Berry, Huff, McDonald, Milligan Inc.
Engineers, Surveyors

April 15, 2013

RE: Level I-Minor Residential Development Review Site Plan Revisions
Level II-Preliminary & Final Site Plan Development Revisions
Chabad Lubavitch of Maine LLC
Pomeroy Street

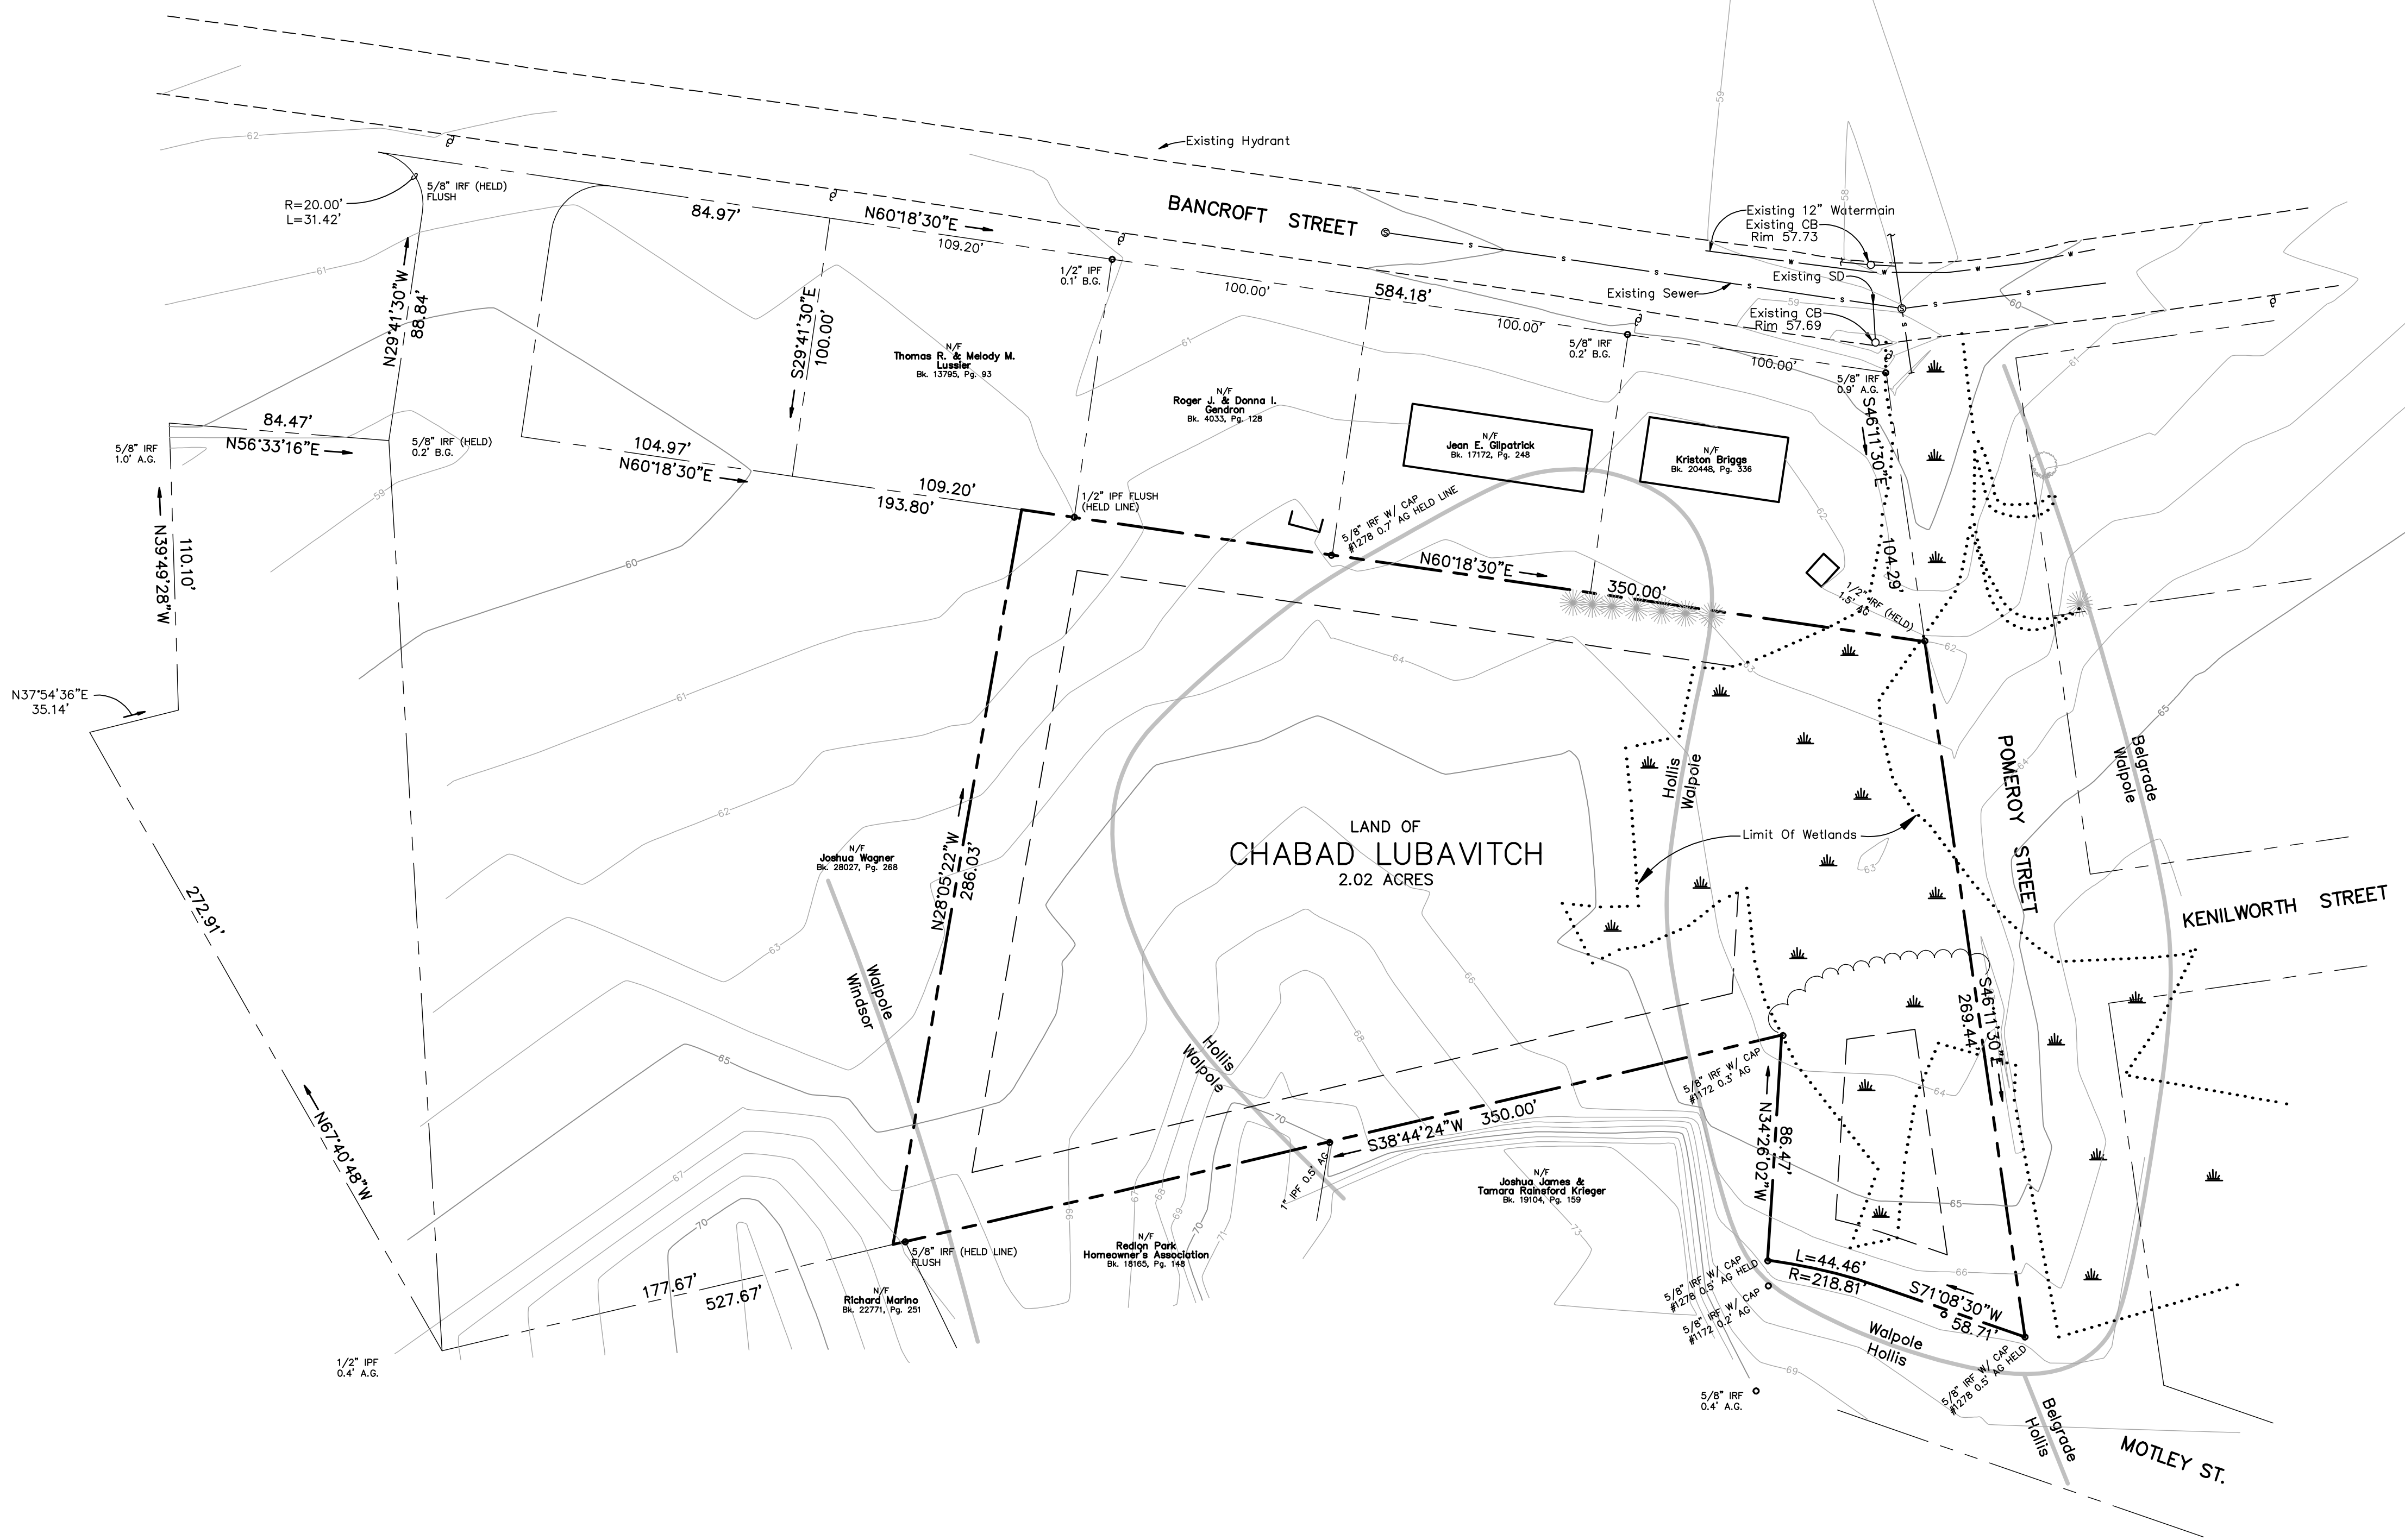
1. The turnaround along Pomeroy Street has been redesigned as requested to meet the City Technical Manual, Section 1.3 (See sheet 1 of plans).
2. The sidewalk on both sides of Pomeroy Street has been eliminated as also requested by the City. The applicant is seeking a waiver from the requirements for a sidewalk (see note #16 on sheet 1 of the plans). The applicant requests this waiver to reduce the roadway cross section in order to protect the wetlands located along the western boundary of the Pomeroy Street Right of way. The following is justification for this waiver citing the specific waiver criteria listed in the City of Portland Land Use Ordinance-Section 14-506:

8. A swale has been designed along the Western side of Pomeroy Street to direct runoff within the wetlands to the existing catch basin along Bancroft Street (see sheet 1 of plans).

9. The location of the proposed driveway and turnaround along Pomeroy Street has been have been switched as requested by the City (see sheet 1 of plans). As mentioned above the turnaround has been redesigned to meet the City Technical Manual.

10. The applicant also requested that the proposed house location be shifted closer to the proposed Pomeroy Street (see sheet 1 of plans).

**POMEROY STREET
PROFILE**

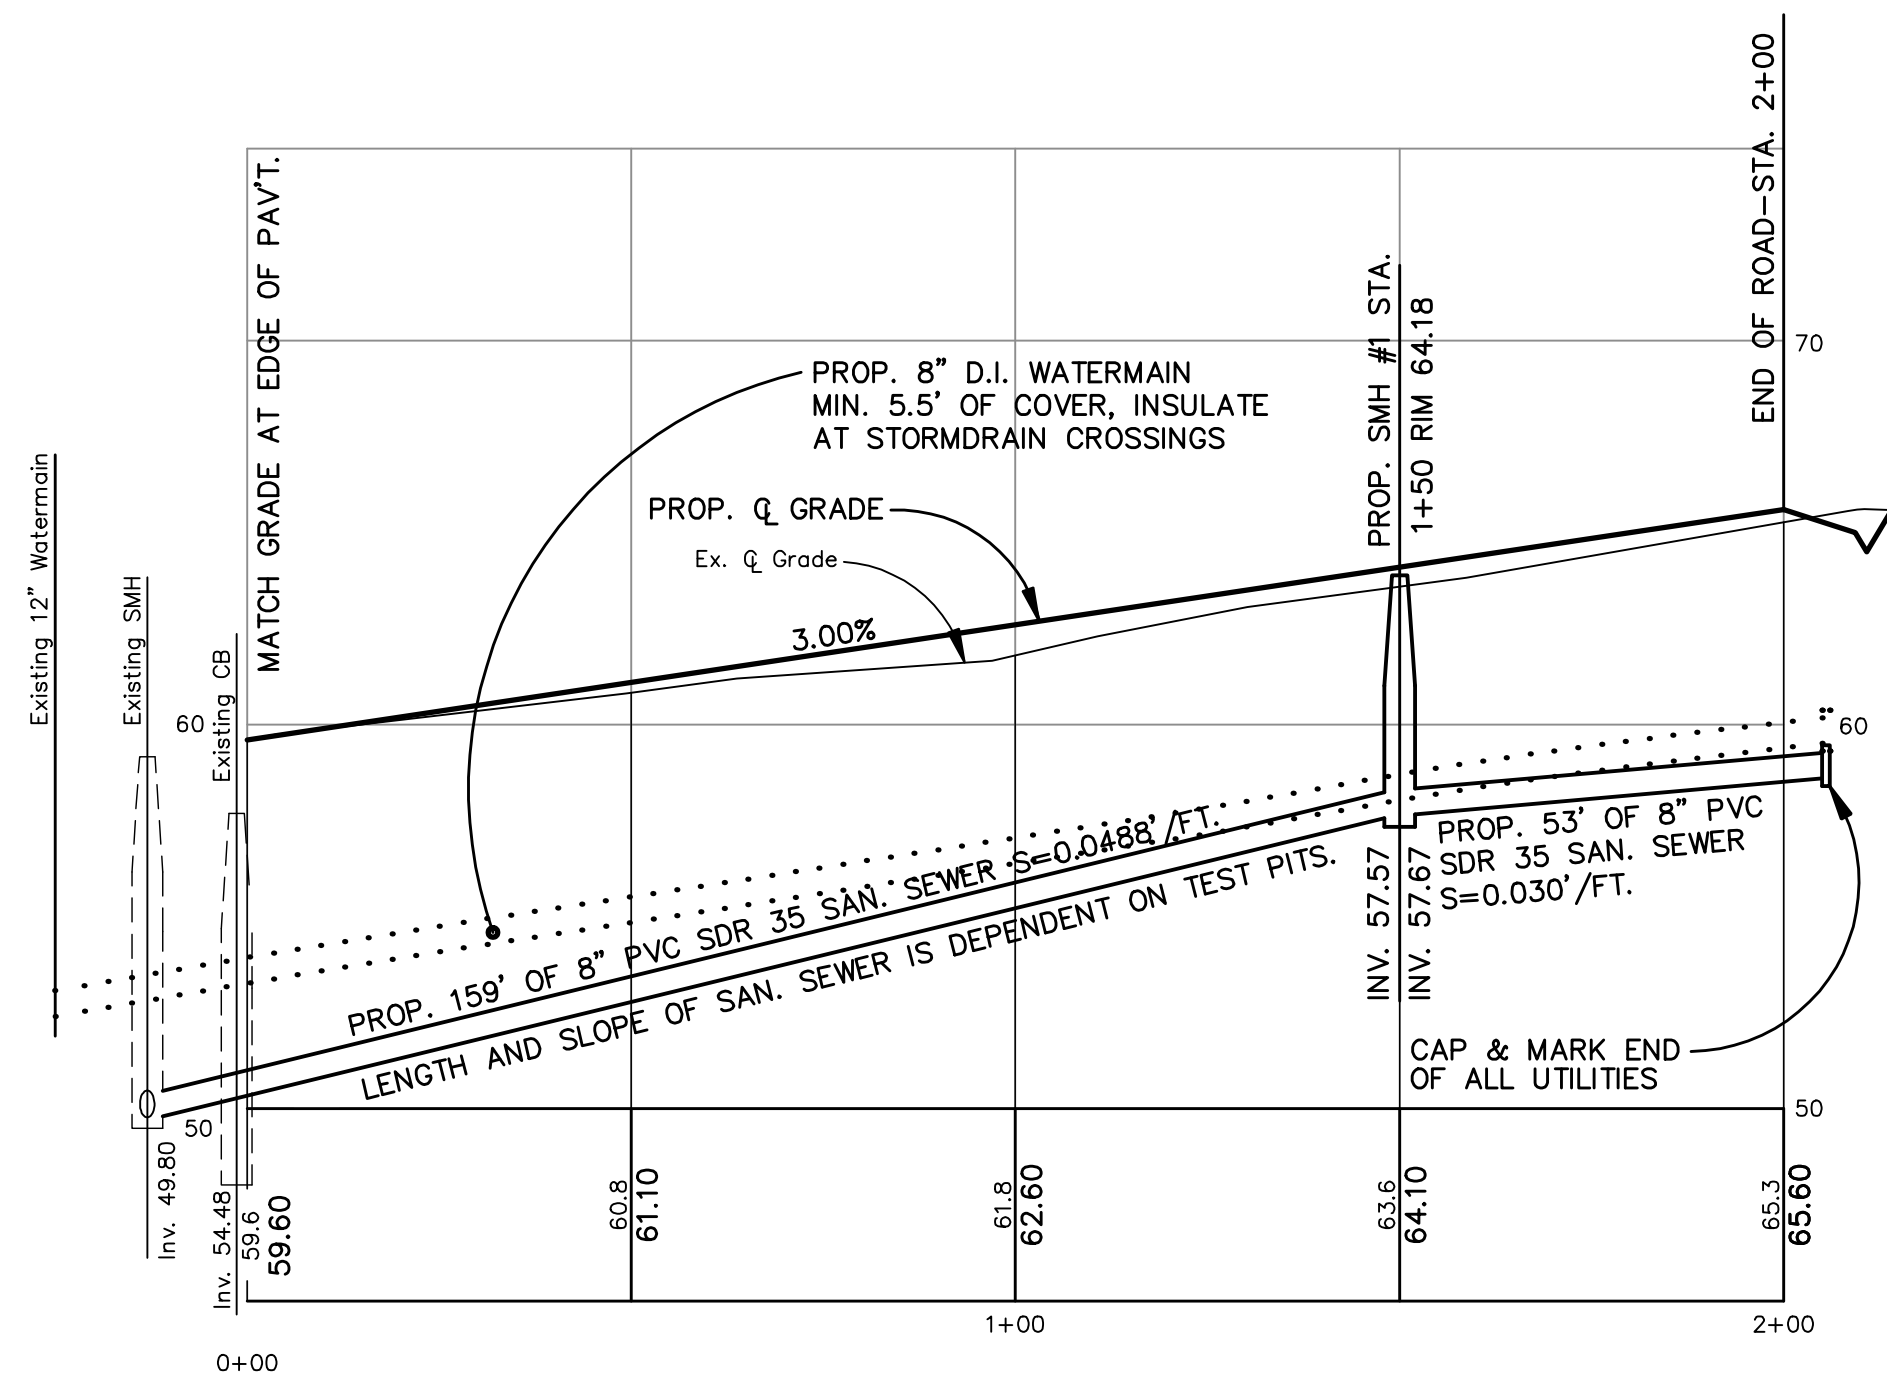
5. The proposed roadway has been super elevated, meaning there is no crown in the roadway. The entire roadway slopes down (at a 2% cross slope) to the Eastern side of the roadway. This was requested by the City to alleviate concerns of the abutters on drainage issues. The overall design has been completed to try to reduce the impacts to the abutting wetlands and the abutting home now or formerly owned by Kriston Briggs. The existing grades along this property have been maintained for the most part (see profile of proposed Pomeroy Street on sheet 3 of the plans).
